## DEVELOPMENT HEARING OFFICER (DHO)

### Parks and Recreation Department

#### **PR-2019-003169**

SD-2023-00132 – PRELIMINARY PLAT

**SAGE PARK
SKETCH PLAT**

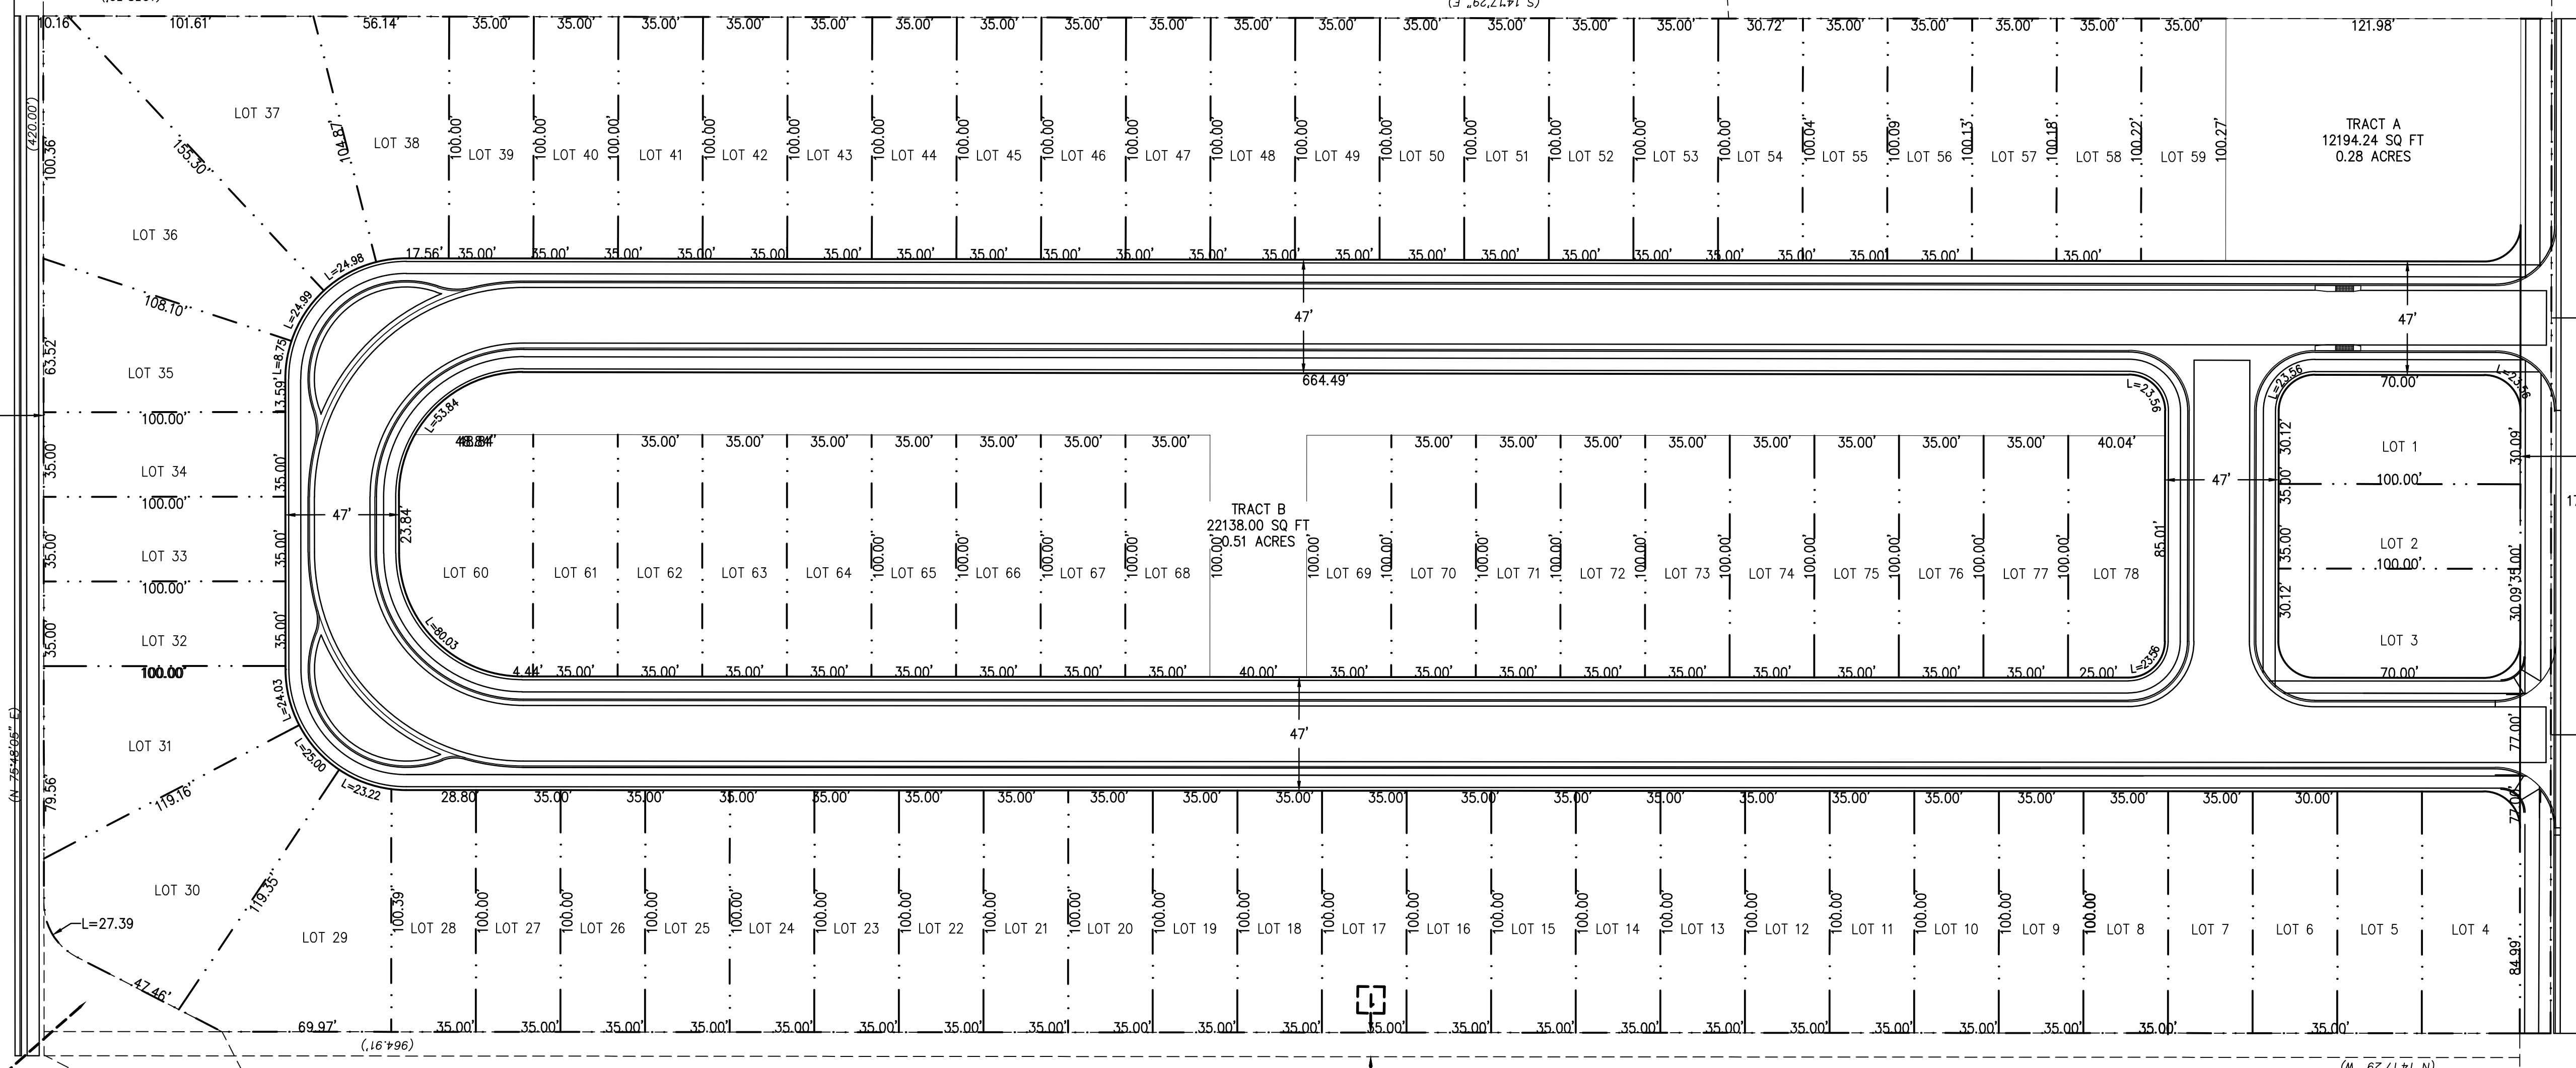
The northwest corner of the property is labeled City of Albuquerque Amole Del Norte Diversion Channel is sufficient space for a trail. Per the MRCOG's Long Range Bikeways System Map, the "Bridge to Rio Bravo Trail" is proposed to continue near this site, but not planned for the near future.

Proposed trail in drainage channel ROW to west of subject site – does the applicant know what development is going in in that site?

Recommended including an access on the San Ygnacio side to trail with some low water landscaping, HOA could have gate, but depending on access width, may also need a bollard or other obstruction to motorized vehicles from entering channel or future trail.

**SAGE PARK
SKETCH PLAT**

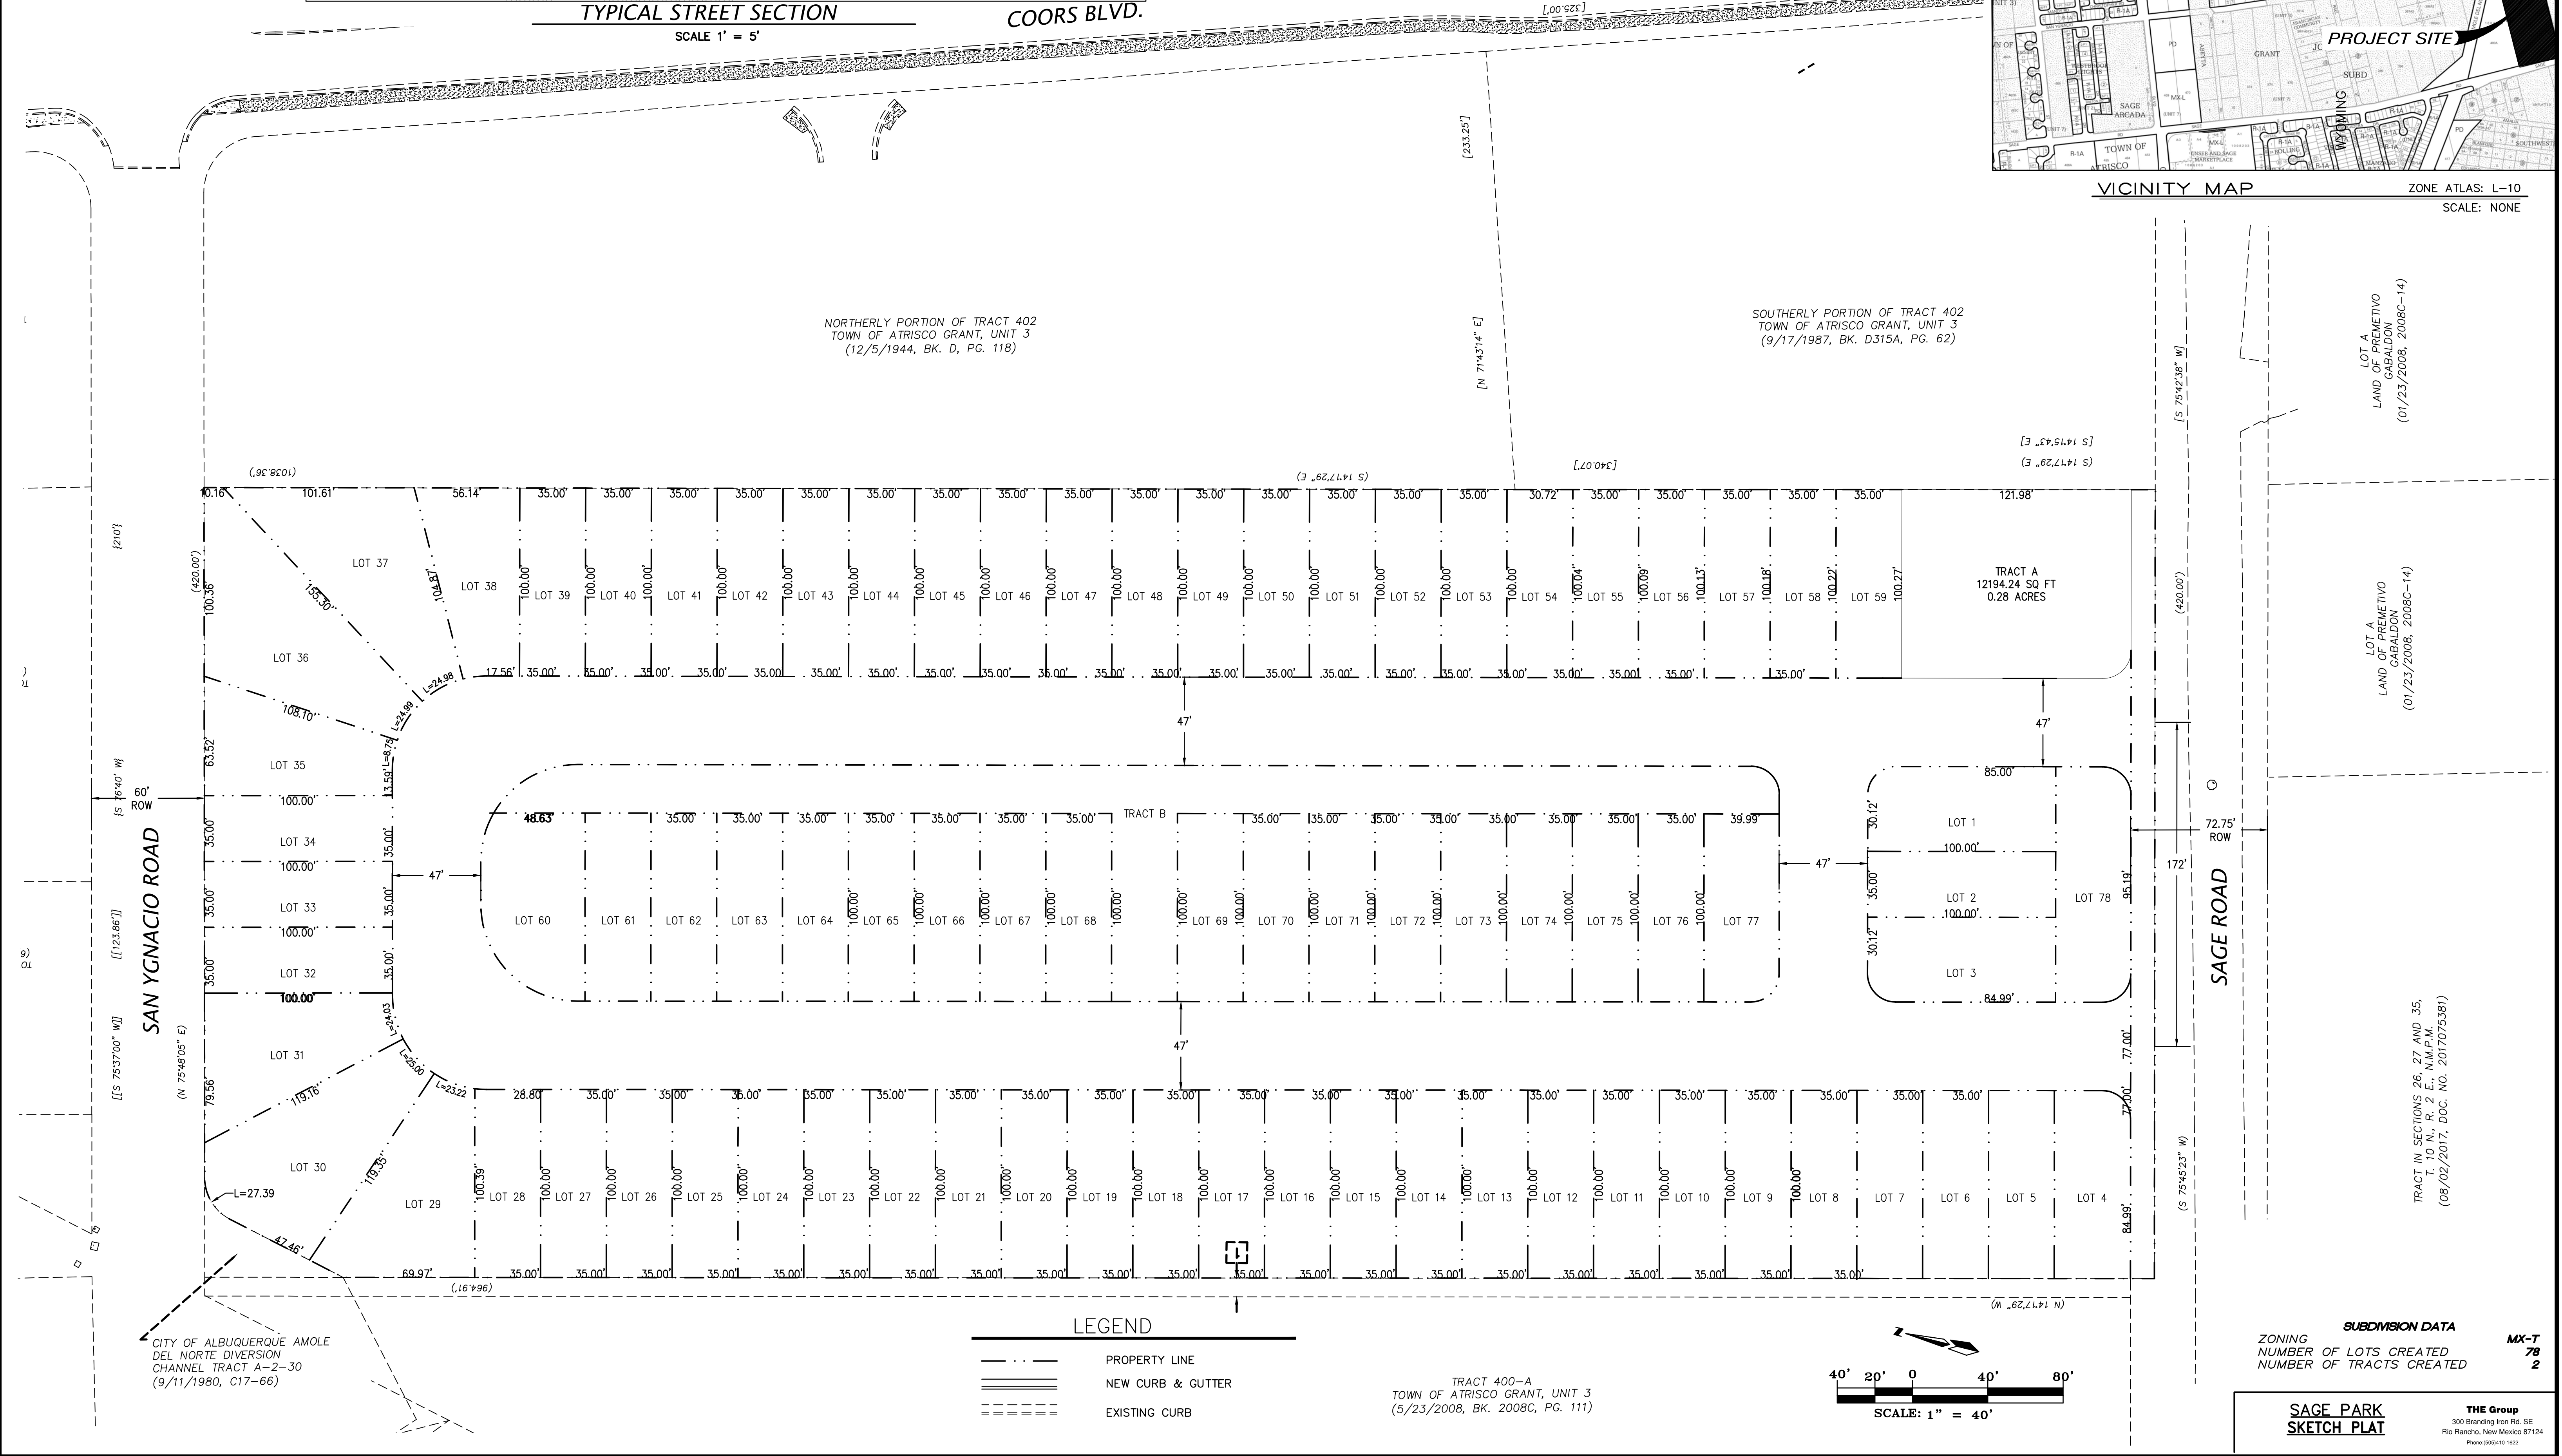
There is proposed trail along the Amole del Norte Diversion Channel which runs immediately adjacent to a property in the NW corner of the subject site. The triangular piece adjacent to the site is owned by the City of Albuquerque. A private access to this property through Lots 29 or 30, would help create a short 80 ft off-street travel distance to future trail as opposed to an existing 750 ft connection point on the southside along Sage Rd. Though not required, this type of access within the proposed development would further many of the purposes listed in IDO Section 14-16-5-3 ACCESS AND CONNECTIVITY. The northern portion of the subject site is not located within a 10-minute walk (1/2 mile) to a park or accessible green space, so looking towards the future – this access could provide great accessibility for residents of the development to more easily and safely access passive recreation and/or multi-modal opportunities for commuting and daily errands/tasks.
